MEMORANDUM

DATE: August 26, 2021

SUBJECT: SP-20-003(SP-19-001) – Sterling Ranch Phase II
Fifth Submittal

Engineering Division

### PRELIMINARY PLAN

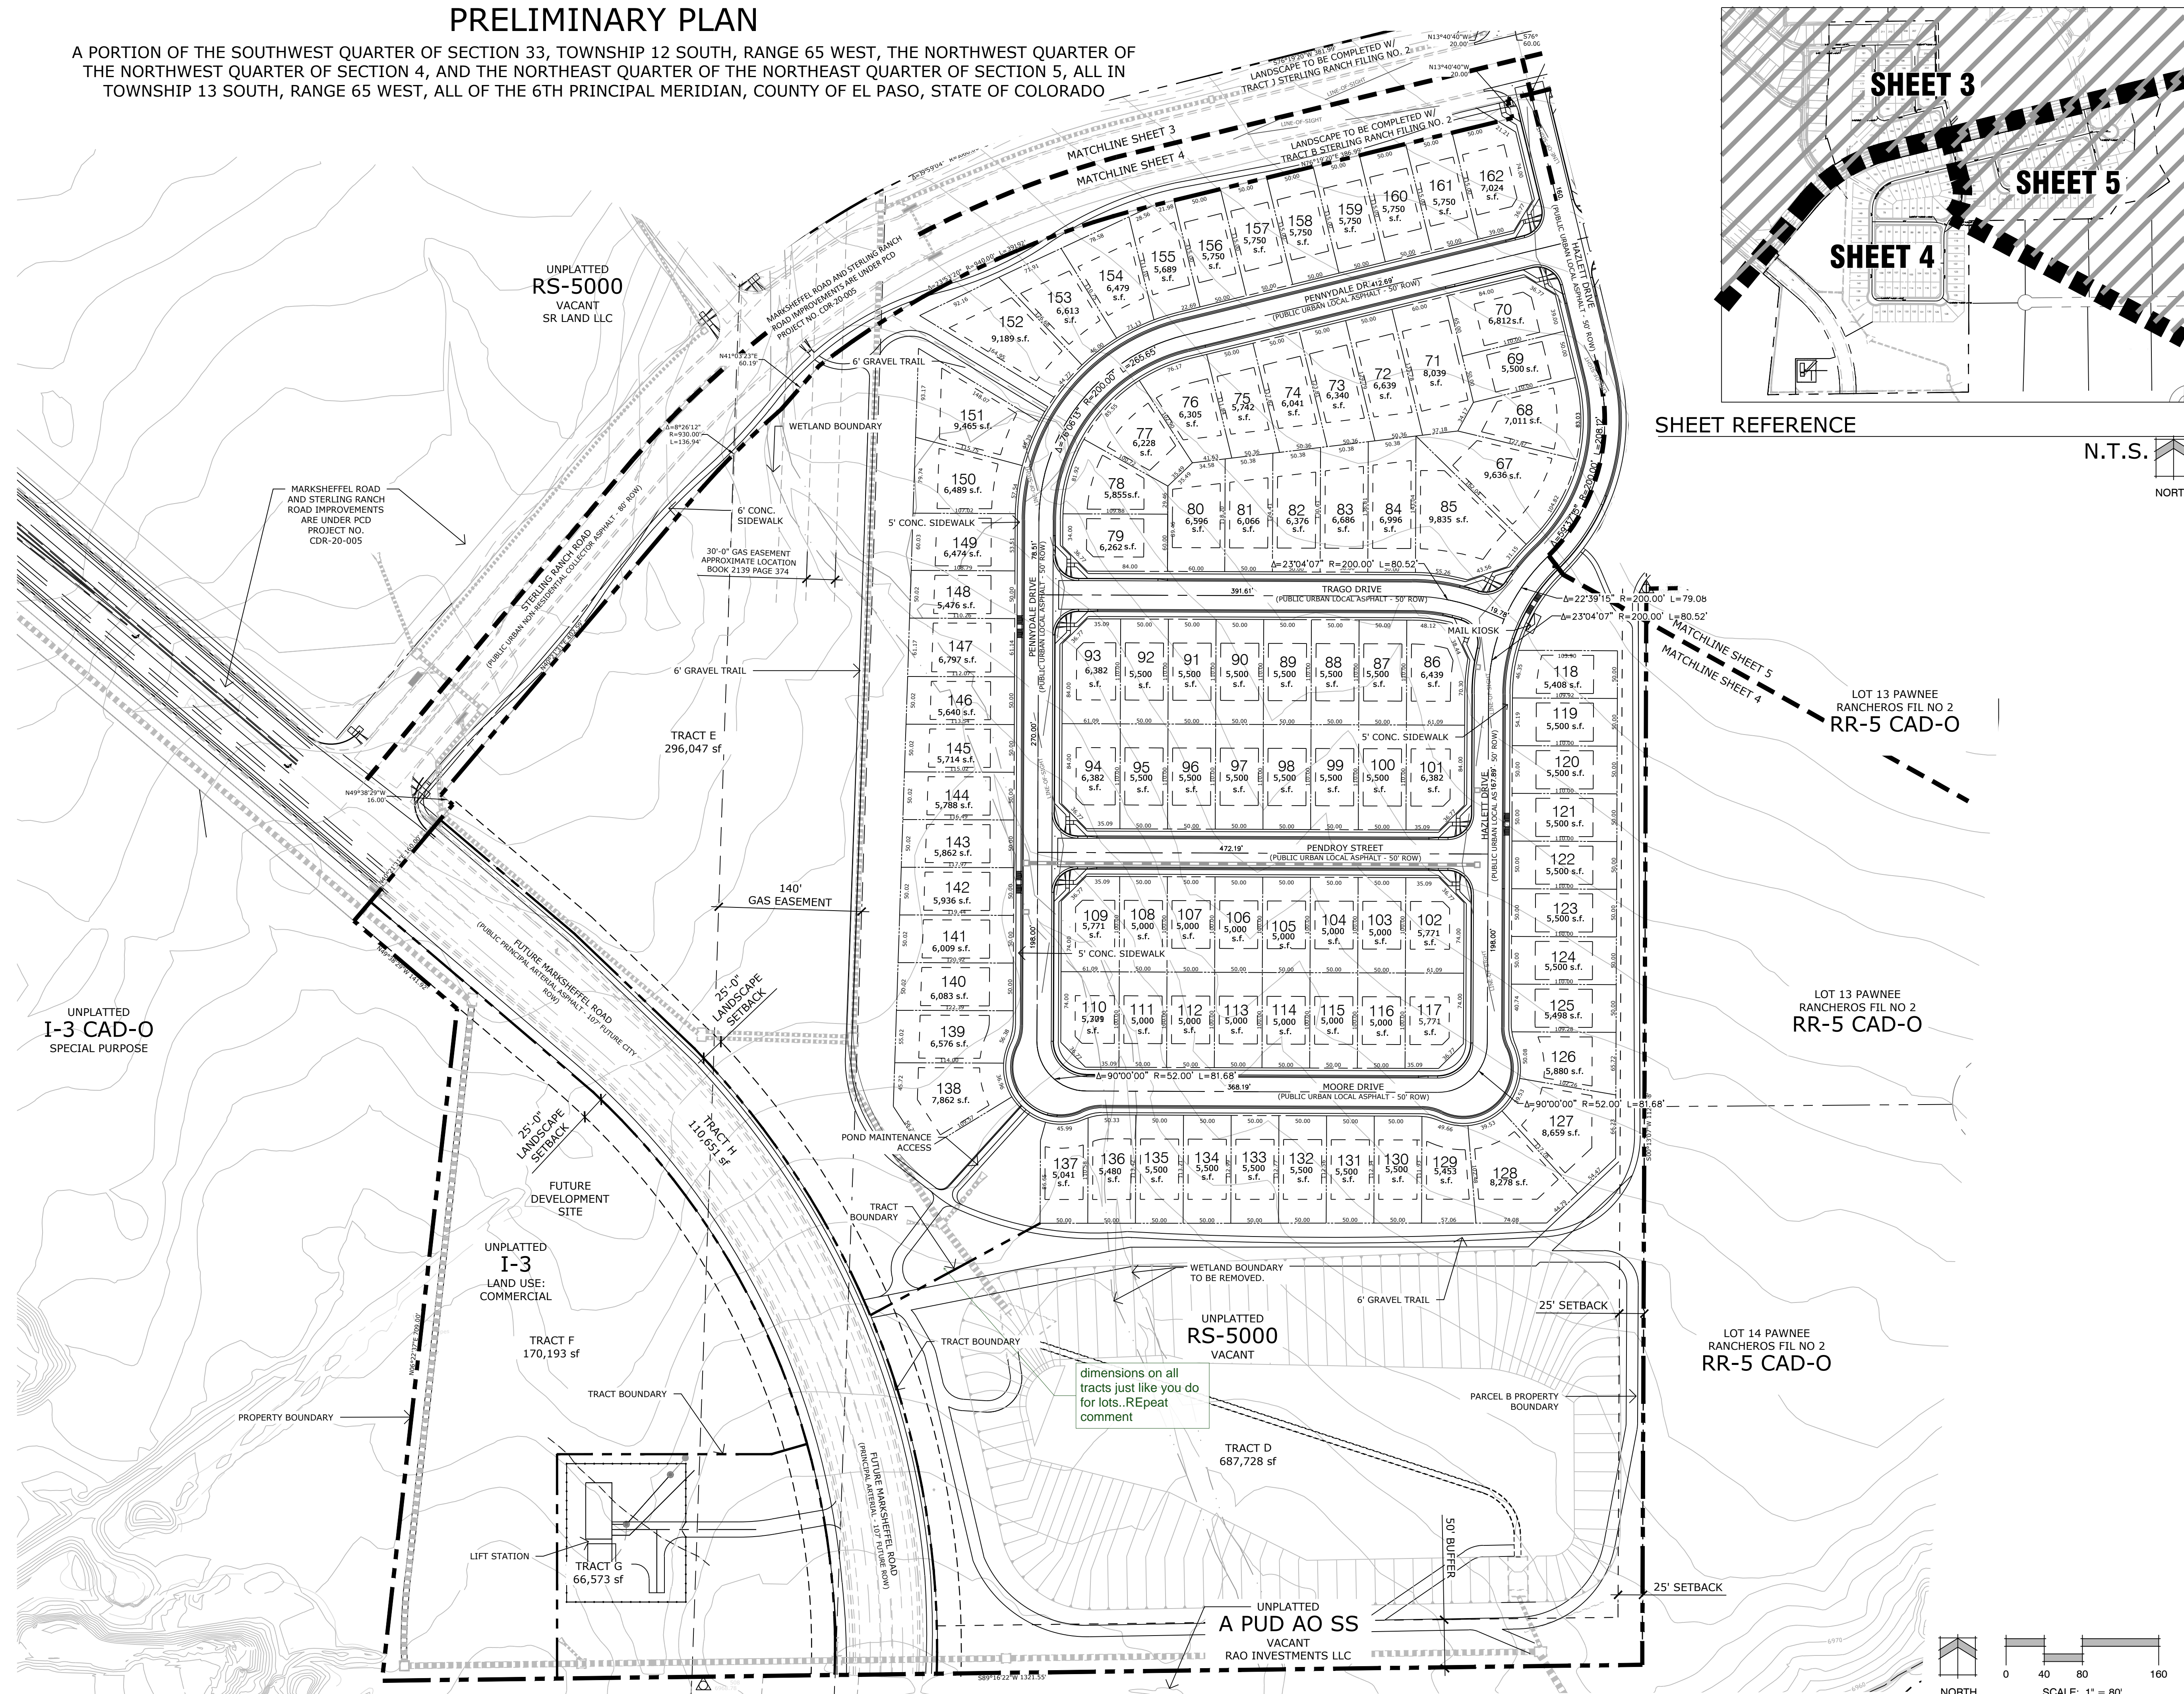
1. Ensure that all checklist items are provided (reference planning comments and redlines).
Partially resolved;
 - a. Show all proposed drainage easements. *Partially resolved; show the additional easement on the school site per redlines. Verify whether an overflow easement and swale will be provided from the west Barbarick drainage facilities south (see drainage report comments).* **Resolved; note: the easement will need to be a separate document approved prior to grading and referenced on the GEC Plan. Resolution or redesign of the overflow location is required based on school district comments.**
 JR Response: the emergency overflow path was revised to drain towards the west.

- b. *Resolved.*
2. **through 5 - Resolved.**
3. *Resolved.*
4. *Resolved.*
5. See Preliminary Plan redlines for additional comments. *Partially resolved; see updated/remaining redlines.* **Partially resolved; see updated/remaining Planning redlines and this redline on the cover sheet: Unresolved; see remaining redlines.**

Response: remaining redlines addressed.
